**Sent:** 29 February 2024 09:48:03  
**To:** Planning Reps  
**Cc:**  
**Subject:** Comments on DA/ 24/00026/COU at 110 Milton Street  
**Attachments:** ufm75\_COMAIL-\_Consultation\_Email\_letter.pdf

**REFERENCE NO.** 24/00026/COU

**PROPOSED DEVELOPMENT** Change of use from residential dwelling (use class C3) to a care home (use class C2) to provide supported accommodation for either Children or Mothers and Babies

**LOCATION** 110 Milton Street  
Swanscombe  
Kent  
DA10 0DT

Proposed Ground Floor Plan
Scale 1:50

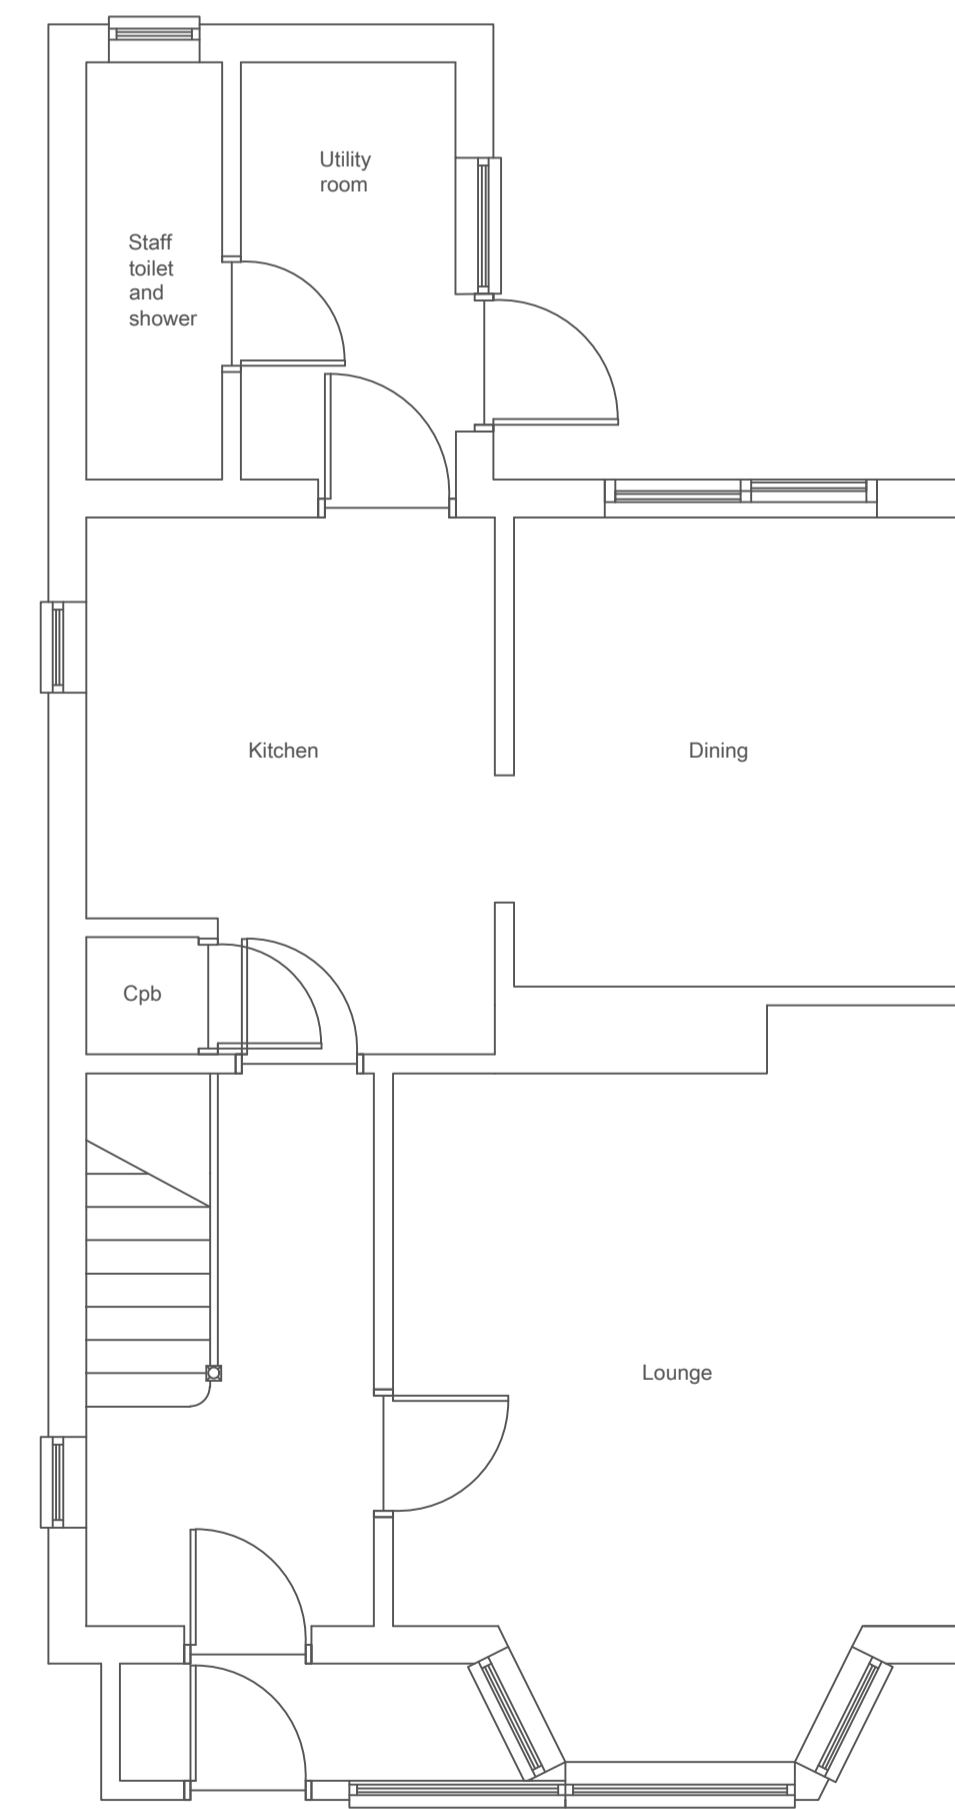
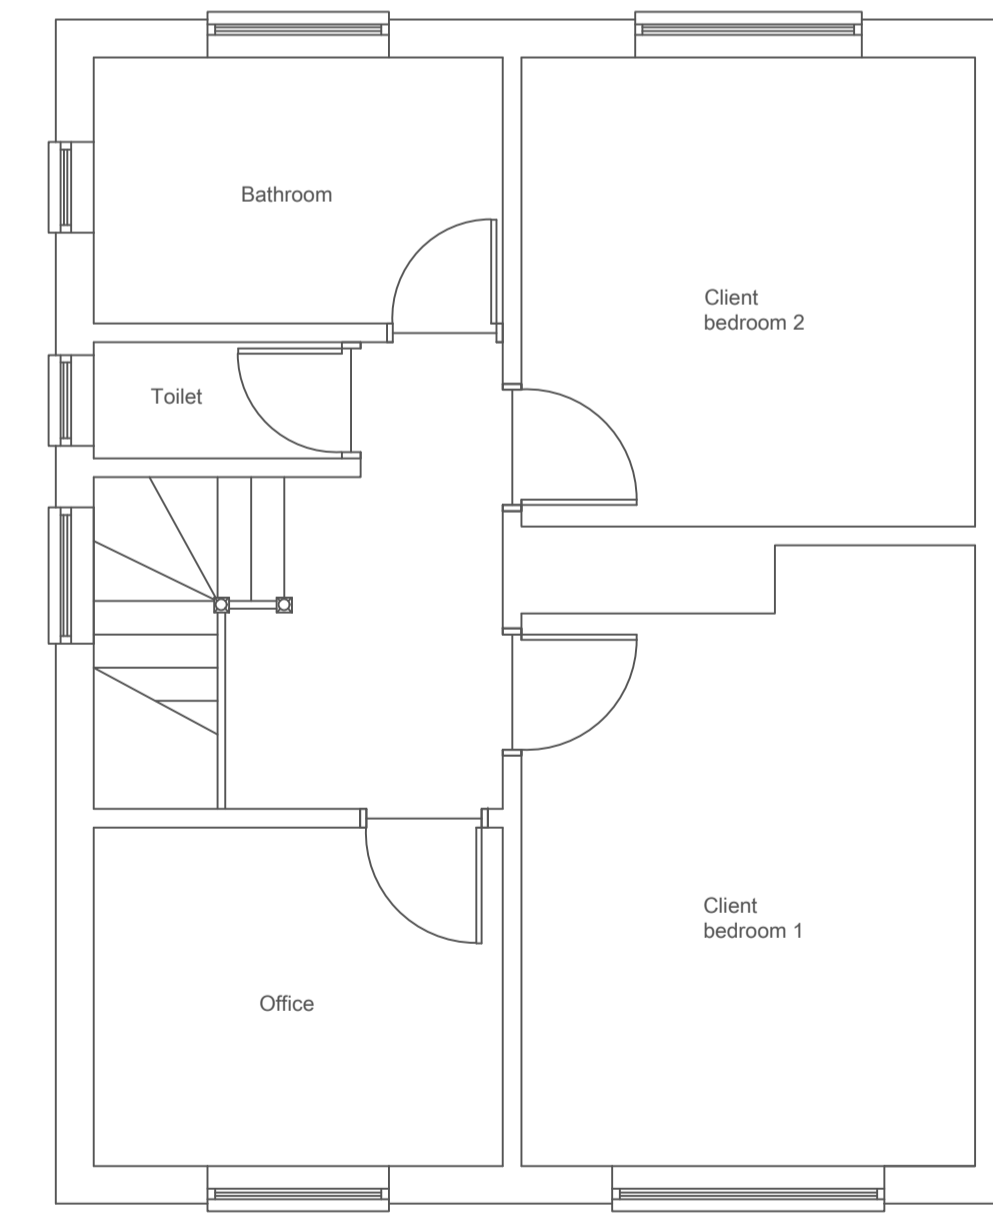
The building itself has limited space and facilities for shared use, and with the supporting statement outlining up to 10 members of staff coming to site the current parking provision is insufficient.
